CITY OF ALBUQUERQUE

**Re: Raising Cane's Restaurant
SWC of St Joseph and Coors
Site Plan
Engineer's Stamp 3-20-24 (G11D067D)**

Based upon the information provided in your submittal received 3-21-24, the above referenced plan cannot be approved for Building Permit until the following comments are addressed:

SITE KEYNOTE PLAN

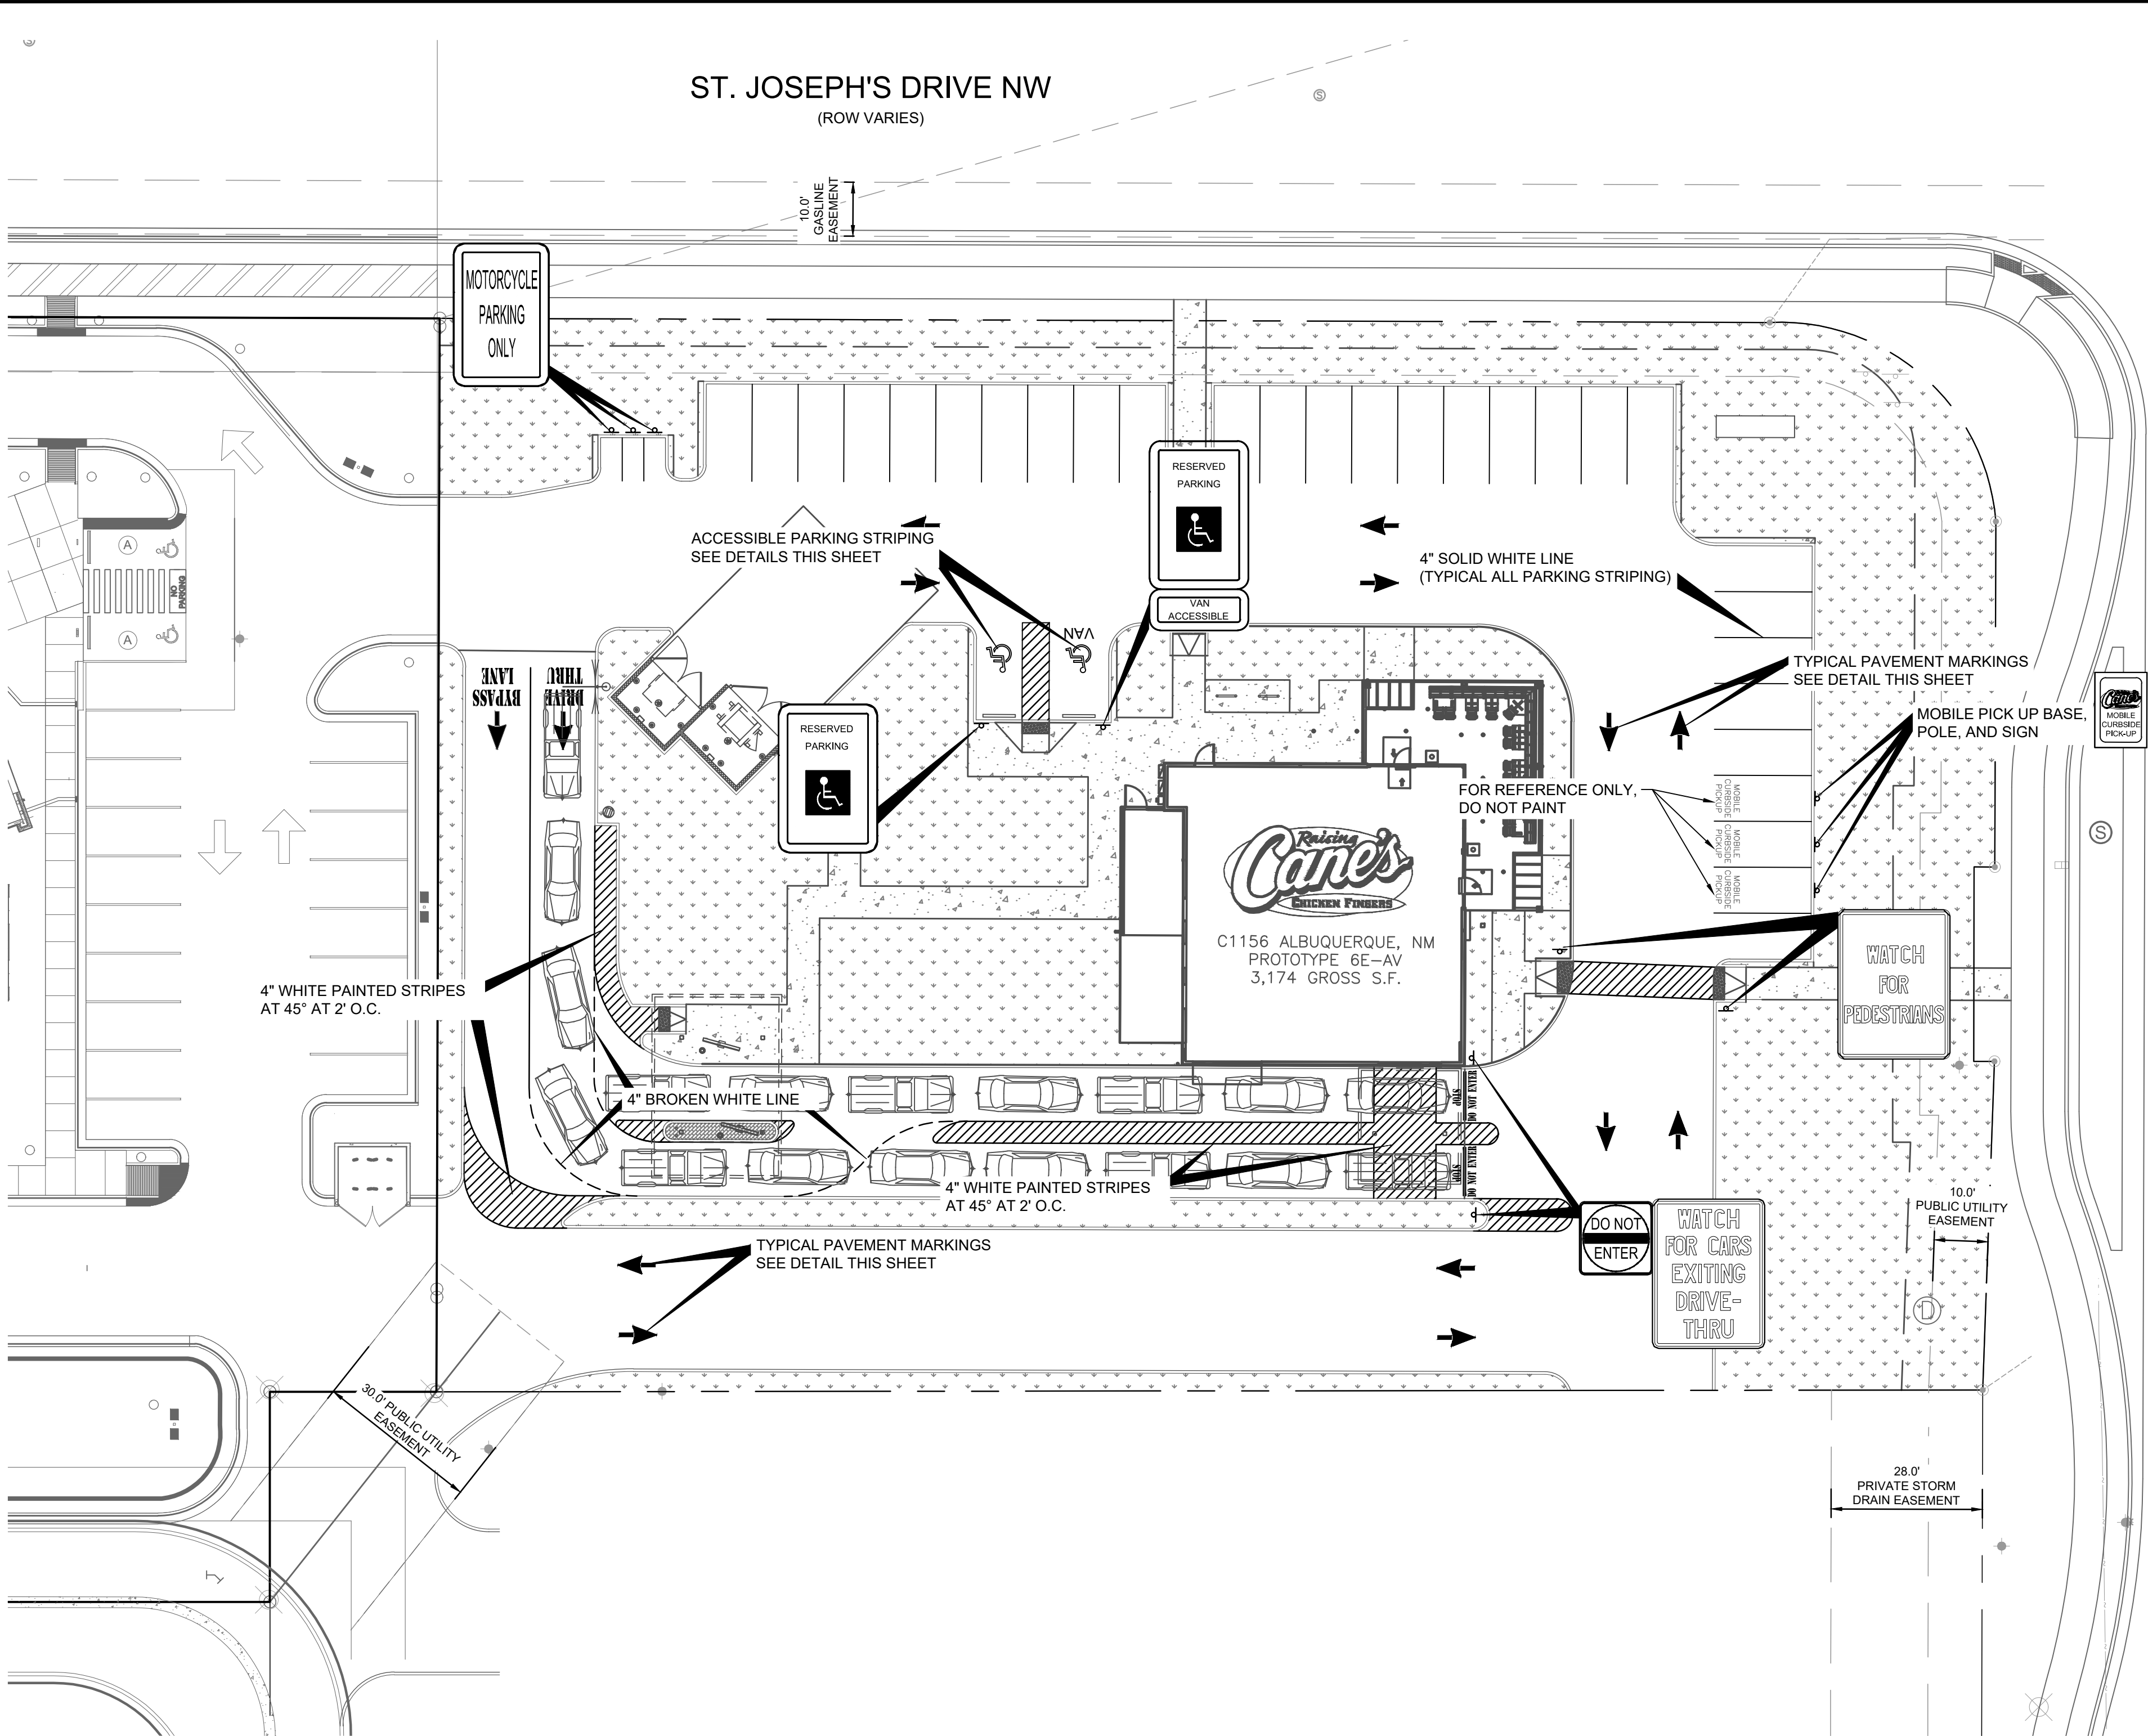
1. The entrance/exit at the private circulation road appears to have vehicles entering and exiting from three businesses with the Raising Cane's entering/exiting on a 45 degree angle at a 90 degree bend in the road. It is not clear how this intersection will function. The 2024 02 06 Oxbow Composite Plan Model (1)-Developer.pdf shows a better intersection as the Lot 6 entrance is 100 feet or more south of the 90 degree bend. This issue was discussed with Sydney (sp?) at Kimley Horn and we discussed showing the curb line across Lot 6 per the 2024 02 06 Oxbow Composite Plan Model (1)-Developer.pdf.

2. If this project is constructed before the bank to the west, a minimum of 24' wide asphalt will need to be constructed from the site out to the internal circulation road.

3. It appears you are proposing ½ or so of a landscape area along the southern boundary. The 2024 02 06 Oxbow Composite Plan Model (1)-Developer.pdf shows parking spaces in this location. Please coordinate with the project on Lot 6 or the Developer to figure out what is to be built in this area.

4. Please revise the Parking/Site Data table to coincide with local and state regulations:
 - a. Required parking is 17 spaces
 - b. Required accessible is 2 spaces, one Van space (add the van space)

- c. Required Motorcycle is 1 space
 - d. Required bicycle is 3 spaces
 - e. There is no parking requirement for the drive-thru.
5. Provide a detail/keyed note for the bicycle racks. Contractors regularly install racks that don't meet City code. The inverted-U style meet our code as an example. Please let me know if you like more information on rack requirements.

6. The drive-thru lanes are to be a minimum of 12' wide. The minimum inside diameter radius is required to be 25 feet. Provide the three radii at the bend in the drive-thru. The radii can be reduced to 15', if the lanes are 14' wide.

7. The minimum stacking requirement is 12 cars at 20' each. It appears the stacking is 10 cars in the drive-thru lane. The length of a car is not provided. It appears the bypass-lane is a drive-thru lane due to the location of the order board. How does the bypass-lane function?

8. The broken white lines in the drive-thru and stacking lanes may be confusing to drivers, but if can show you have stacking for 12 cars at 20' each, it meets out regs.

9. Please add a note "Broken or cracked sidewalk in the ROW is to be replaced". Landscapers can get carried-away with the skid-steer.
10. Accessible aisle stripes should be blue rather than white.

11. The accessible aisle detail has the non-van space as 9.0' wide, whereas the site plan shows it as 8.5 feet wide.
12. The arrow on the concrete (dumpster pad) should be black rather than white so it is visible. It may help the Contractor to shift the arrows east, so they are both on asphalt.
